TRAFFIC IMPACT STUDY

Jaynes Property
El Paso County, Colorado

May 2022

Please add PCD File No.
SKP225

**2**  
2 OF 4  
SKP225

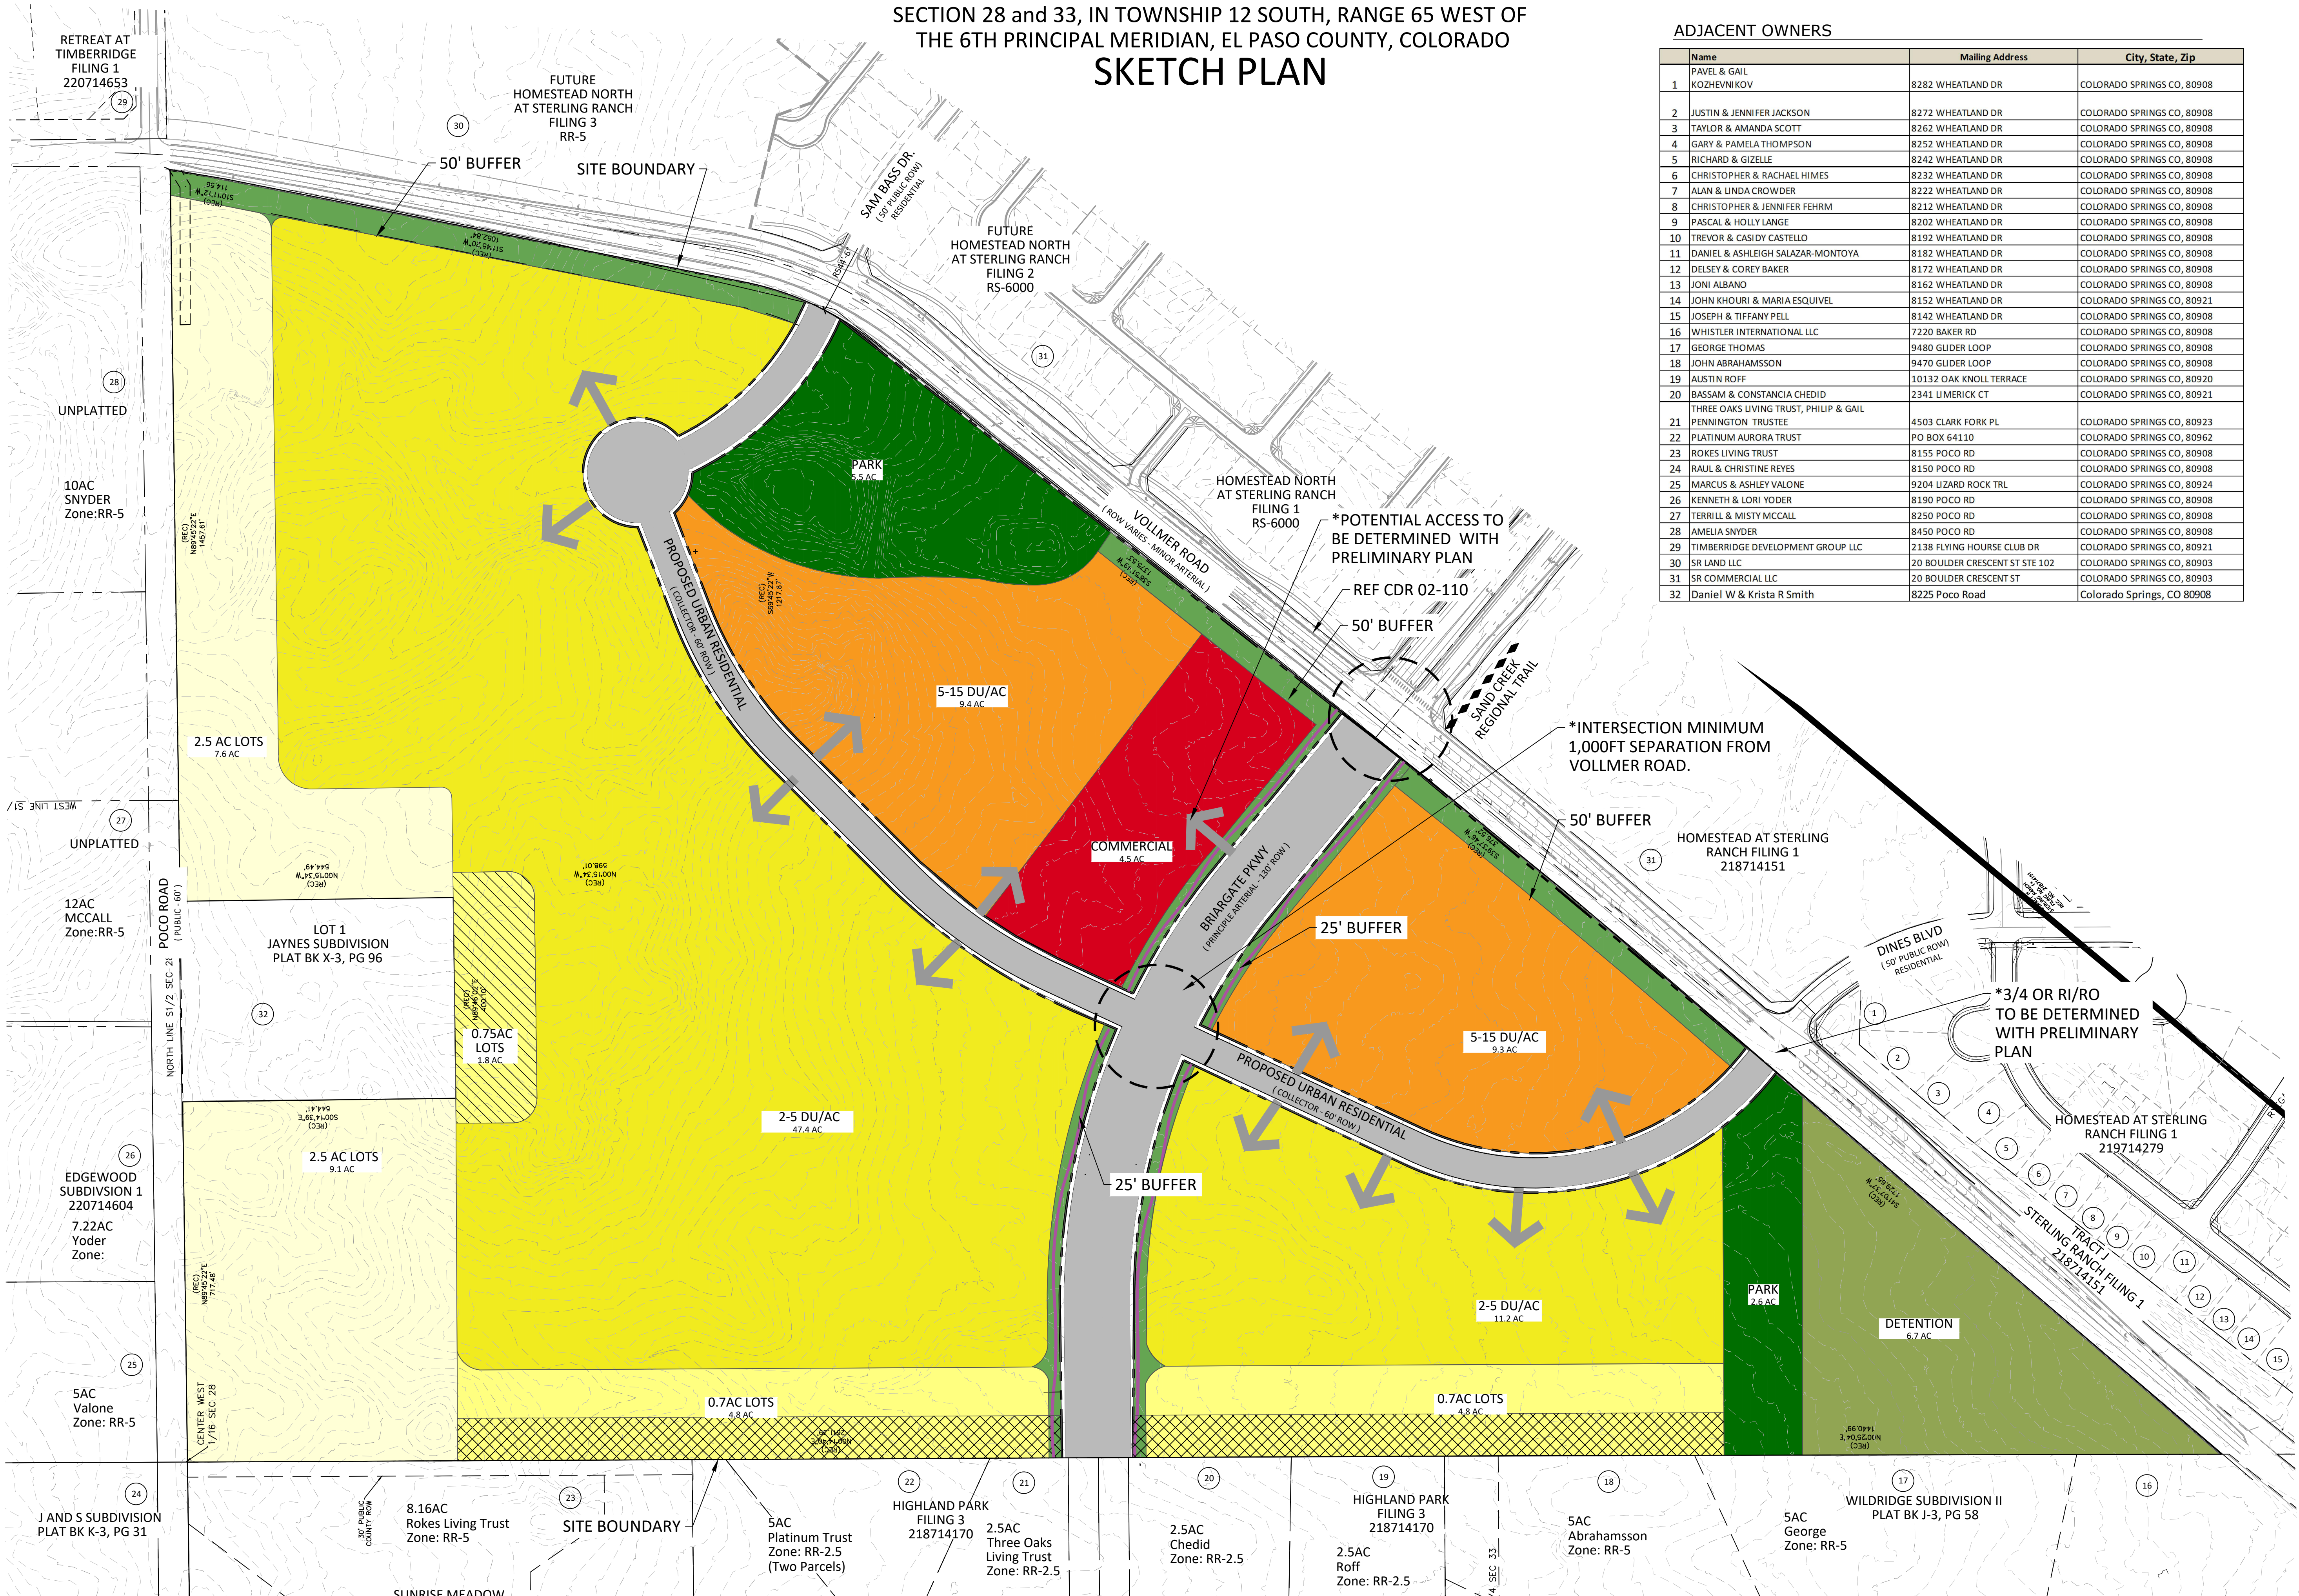
Coordinate with NES so that the appropriate units are accounted for. The letter of intent/sketch plan indicates 615 dwelling units with a density cap of 450 dwelling units per their land use break down.

The sketch plan shows an additional roadway intersection aligned with Dines blvd. Please revise your traffic analysis accordingly.

Also, identify the anticipated classification of the proposed roadway.
